File No: NTH08/01383/03
Your Ref: MP07_0020_Mod 3

**Modification of MP07_0020-Mod 3: Blakebrook Quarry Project (to include Asphalt Plant)
540 Nimbin Road, Blakebrook**

23 August 2019

LISMORE CITY COUNCIL
INTERSECTION UPGRADE
550 NIMBIN ROAD AND BLAKEBROOK QUARRY, LAKEBROOK
EXISTING INTERSECTION AND SIGNAGE

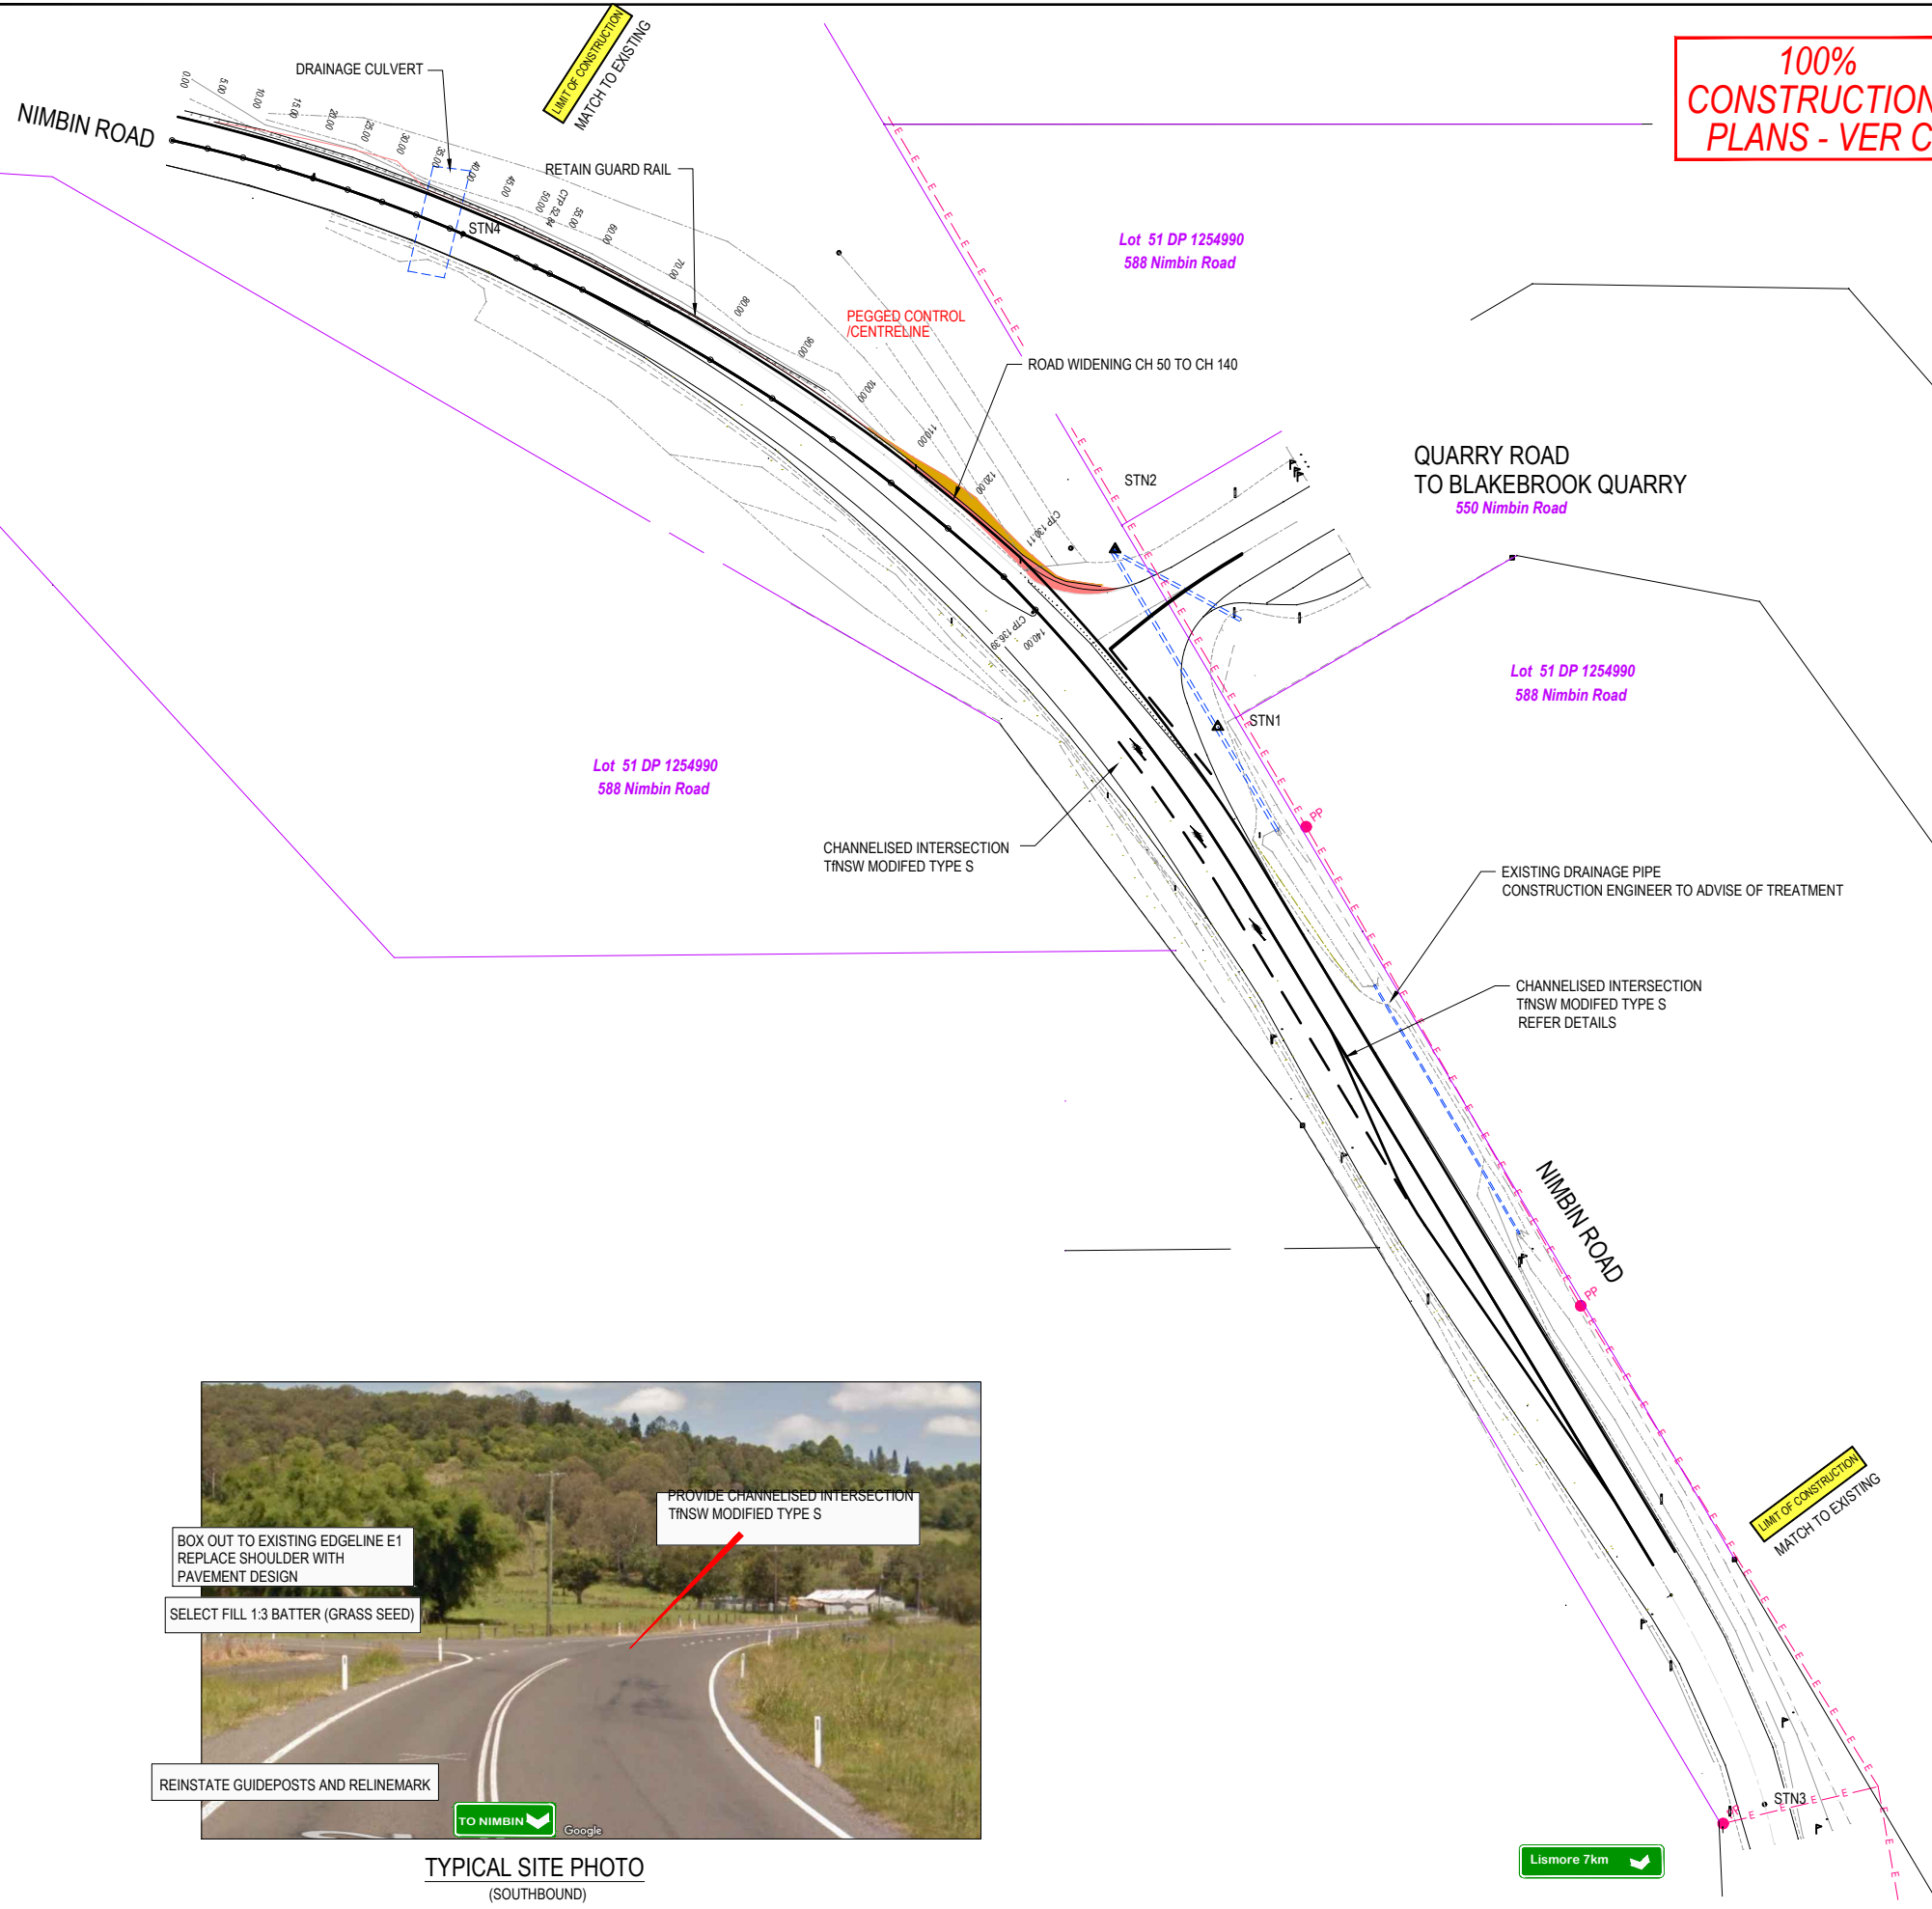
1. The Quarry Access Road and Nimbin Road intersection has a 'Type AUR Intersection Treatment' which is no longer the preferred intersection treatment recognised by Austroads. The intersection should be upgraded to provide an Austroads shortened channelised right-turn (CHR-S) treatment on the major road.
2. It is noted on page 79 (section 6.6) of the Statement of Environmental Effects provided with the application, that '*separate lanes for left and right-turning vehicles may be desirable on the major road for safety reasons*' are recommended. Roads and Maritime supports this position.
